**KIRKLEES METROPOLITAN COUNCIL
INVESTMENT & REGENERATION SERVICE**

Reference No: 2017/62/93660/E

Site Address: 68, Daisy Hill, Dewsbury, WF13 1LS

Description: Change of use from office (A2) to 4 flats, installation of rooflights and new windows and doors (within a Conservation Area)

Proposed Back Elevation B

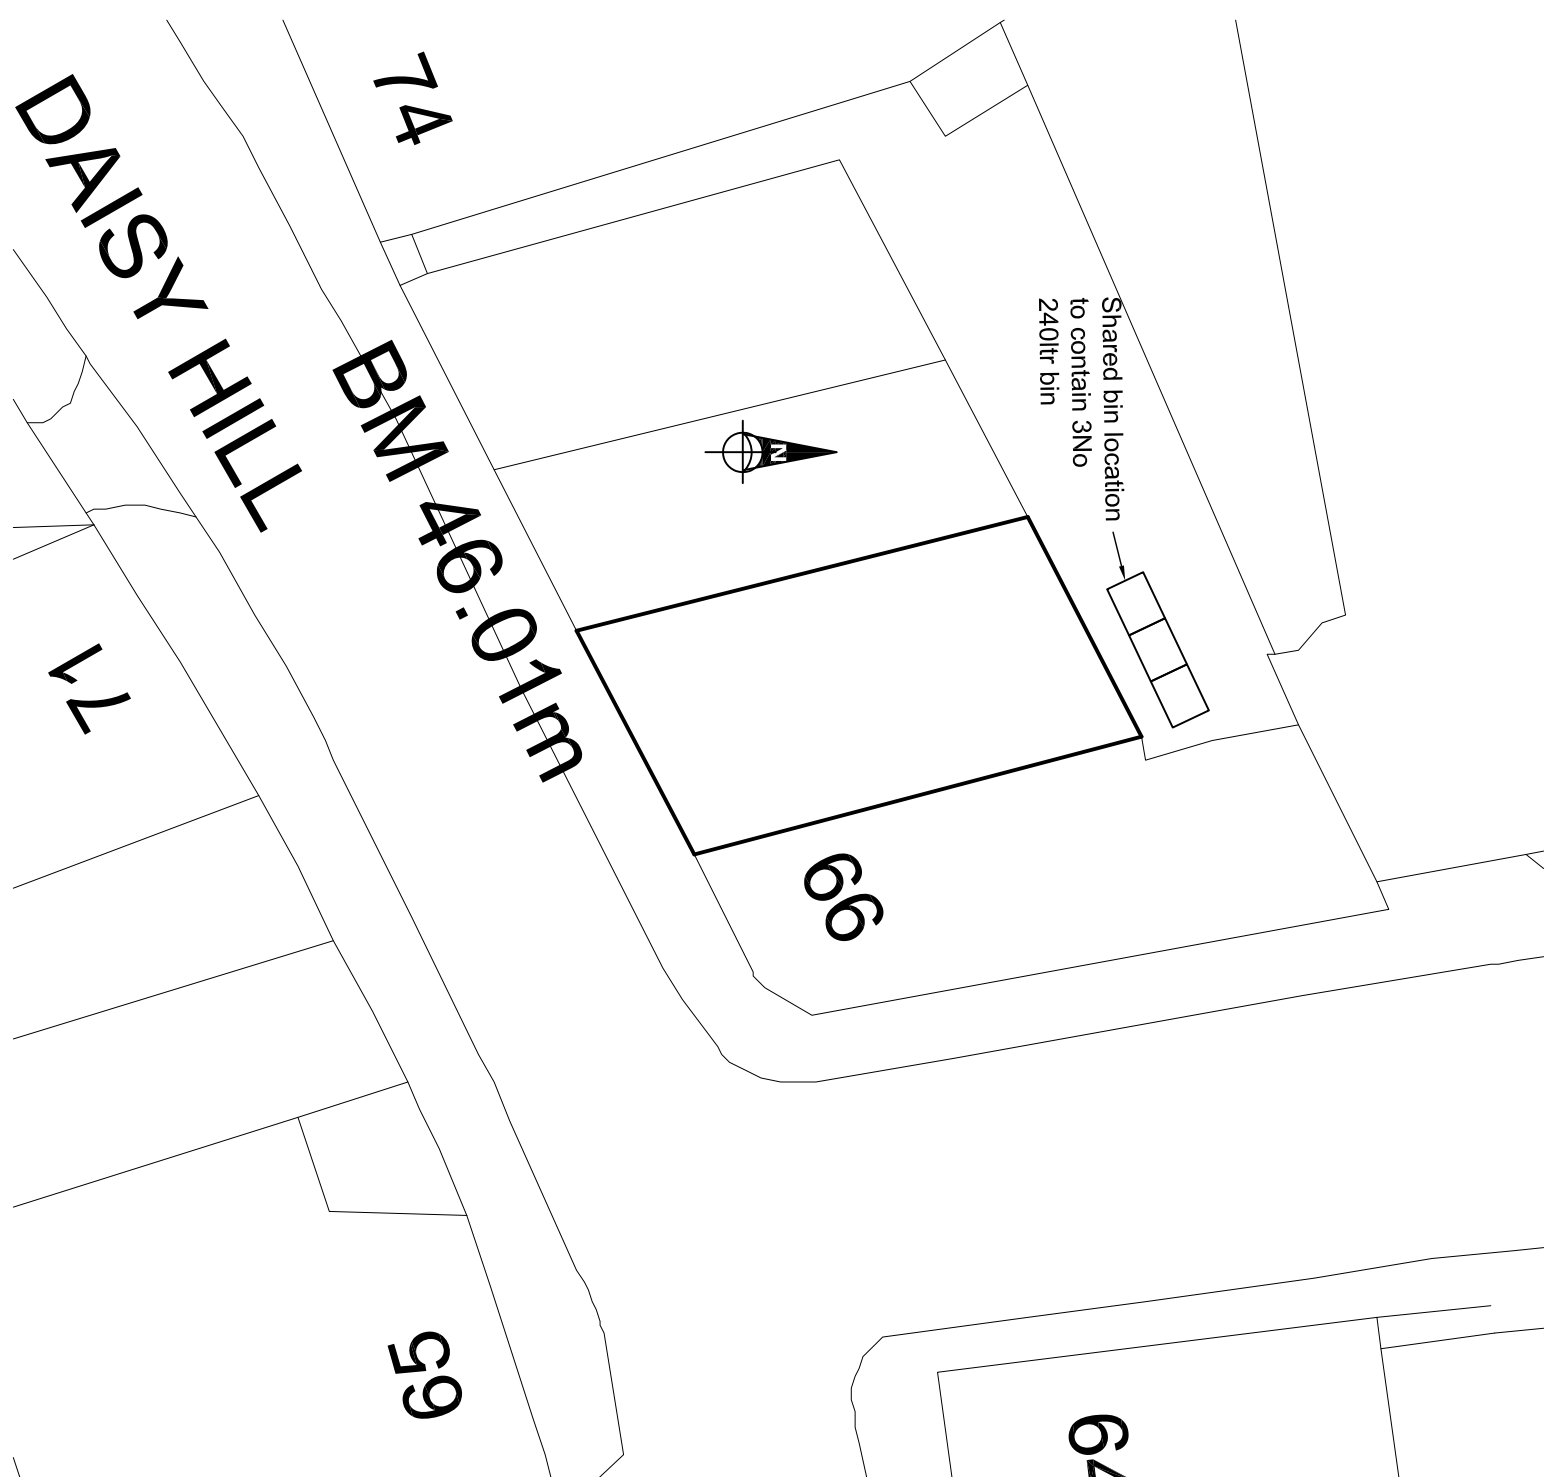
Bin storage details have been provided on the submitted plan WF/07/P03 and are considered to be acceptable from a Highways perspective, in accordance with policies D2 and T10 of the UDP as well as policies PLP21 and PLP22 of the PDLF.

REV: DATE: REVISION:	BY: MM
CLIENT	
PROJECT	
81-83 Daisy Hill Dewsbury WF13 1LT	
TITLE	
Proposed Plans & Elevations	
STATUS	
Planning	
DATE	SCALE
30.09.17	1:50,200@A1
DRAWN BY	REVIEWED BY
	M N Ali
DRAWING NUMBER	
WF/07/P03A

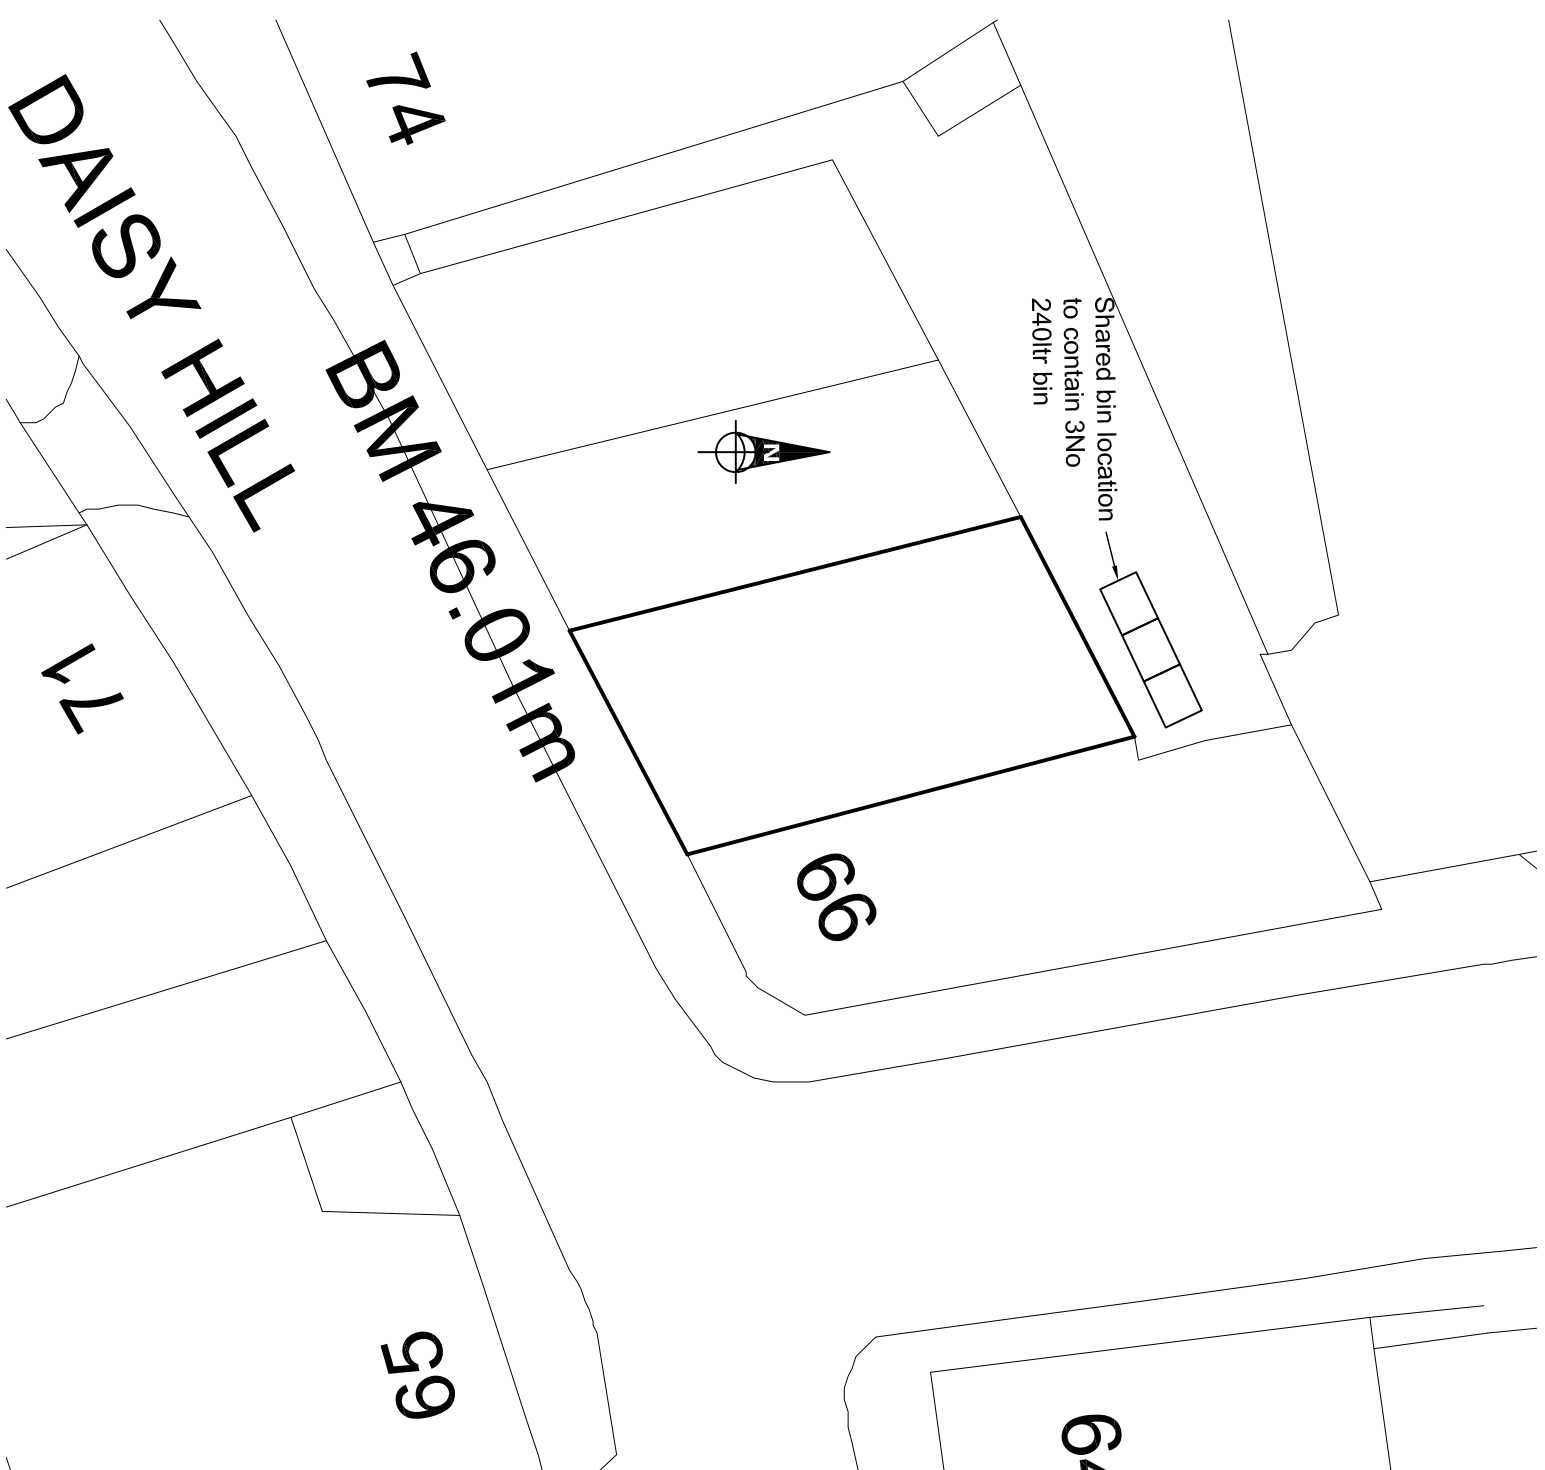
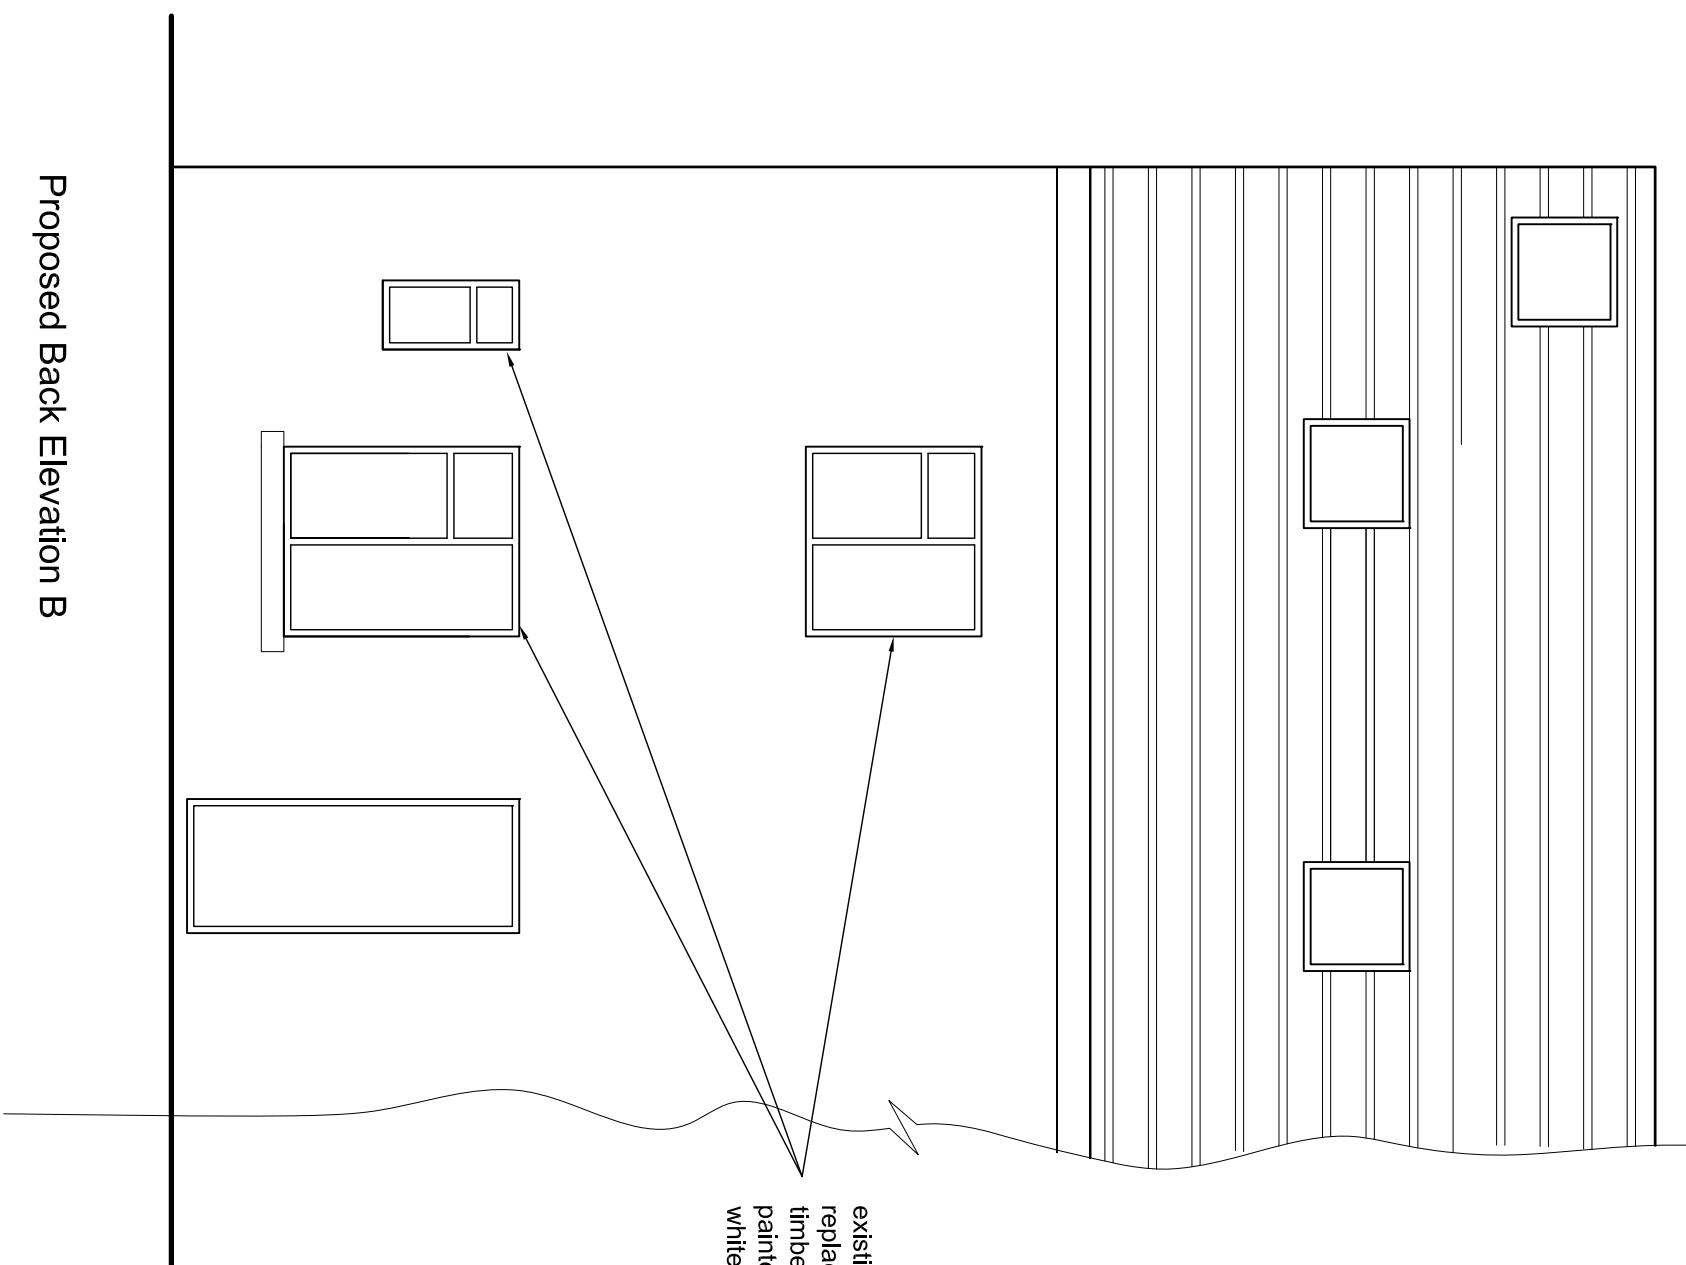
Amendments have been secured relating to the design of the front elevation of the building to ensure that the character of the building is retained and is

more in keeping with the surrounding buildings. The proposals originally included the erection of dormer windows to the front and back however, these were removed during the course of the application.

Following the receipt of amended plans which show changes to the fenestration and openings on the front elevation, the impact on visual amenity and the Dewsbury Town Centre Conservation Area is acceptable. The front elevation of this building makes a considerable contribution to the character of the conservation area and the streetscene. This character and appearance will remain given the simple amended design of the door and window which replace the shop front.

The openings are located in line with the existing openings and are considered to be appropriate. The balance of the openings is apparent in this front elevation and the remaining shop front will be walled up with natural ashlar stone to match the existing building (a sample of which shall be conditioned).

The openings will be constructed from timber with a painted finish and will be set back in the reveal by 75mm minimum. The rooflights will be slim line and conservation style – a condition has been recommended to this effect.

3. All rooflights shall be of a conservation style and shall be installed flush with the roofline on first installation and thereafter retained.

4. New windows shall be of timber construction. Mouldings and timber sections shall be of a traditional design and profile to match those that are existing. No works to install new windows shall take place until design and joinery details (at 1/5 scale) have been submitted to and approved in writing by the Local Planning Authority. The development shall then be completed in accordance with the approved details before the use hereby approved commences and thereafter retained.

5. The facing material used in the development shall be ashlar stone to match that used on the host building in terms of type, size, and colour.

6. All new doors and windows shall be timber/timber framed with a painted finish on first installation and shall be retained as such thereafter.
